Eden Street, Arncliffe Mixed Use Redevelopment (SSD-11429726)
Request for additional information

I refer to the Assessment for the Eden Street, Arncliffe Mixed Use Redevelopment (SSD-11429726). We require additional information as follows:

Figure 10 - Flood Levels & Depths (1%AEP) – Proposed Conditions

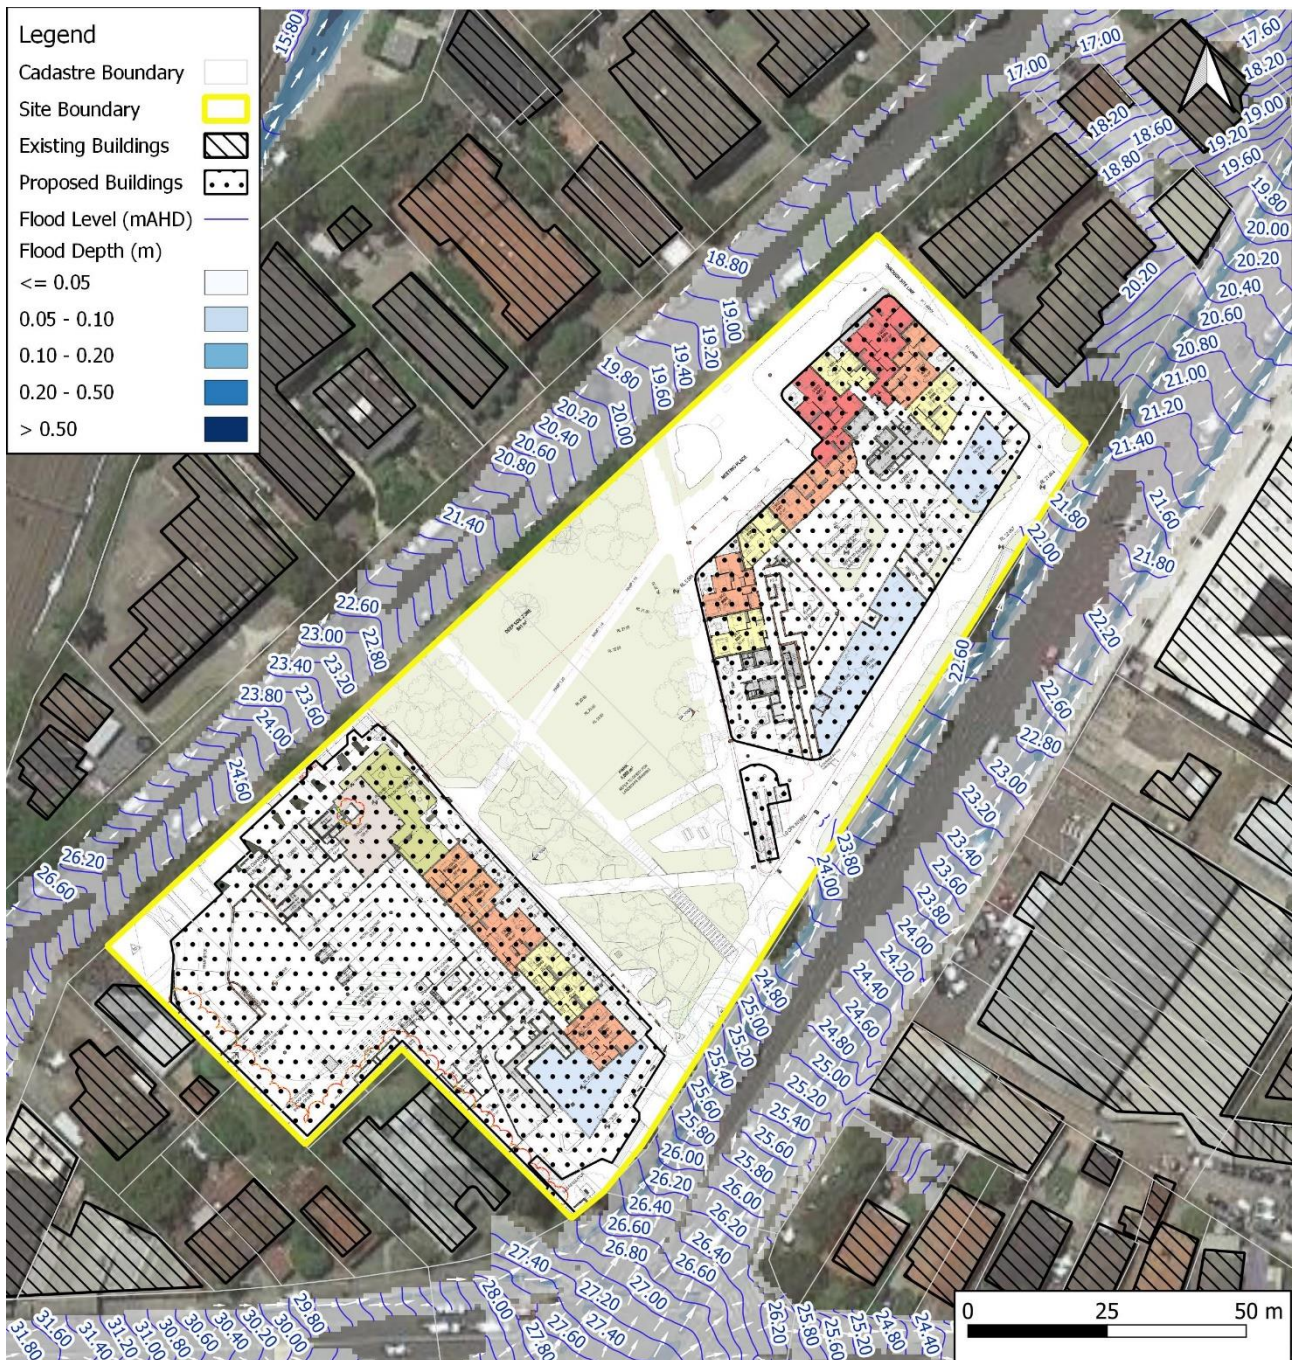
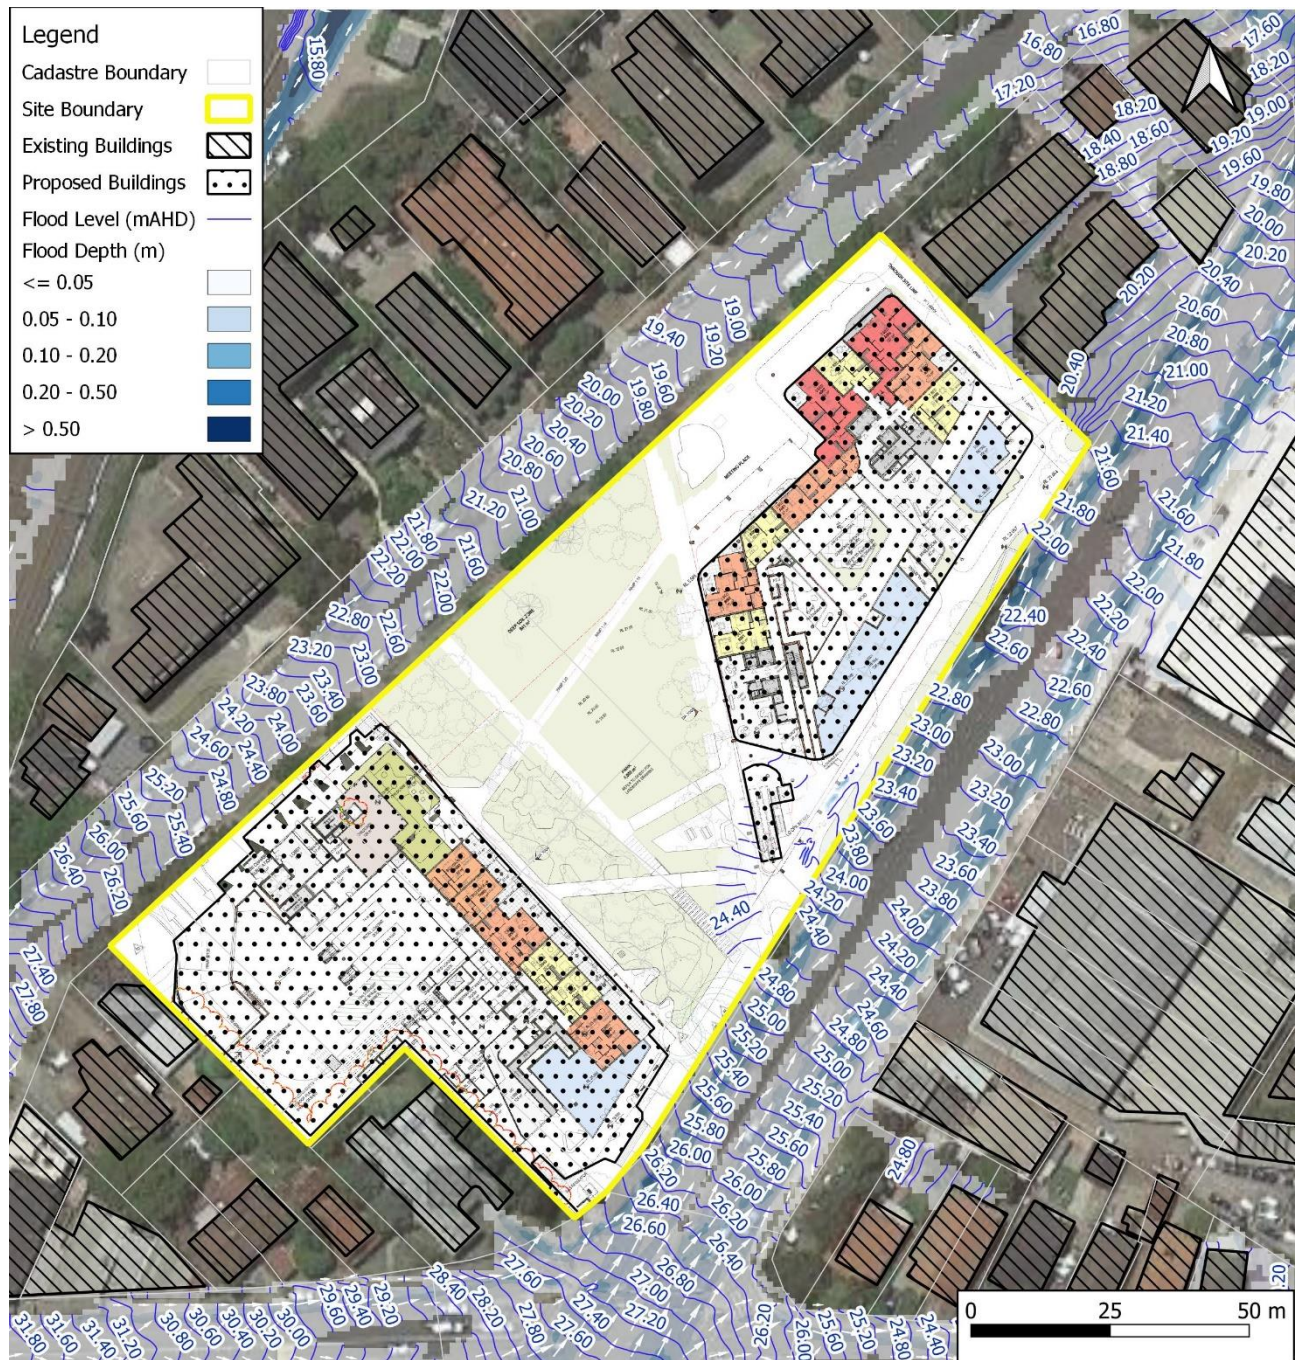
3. The recommended finished floor levels and driveway RLs within the revised Flood Impact Assessment (FIA) do not appear consistent with the levels shown on the proposed plans. Please review the recommendations of the FIA and demonstrate how these have been incorporated into the proposal, including revised plans as necessary. Please also provide the AEP and PMF levels for the site so the adequacy of the recommended levels can be verified.
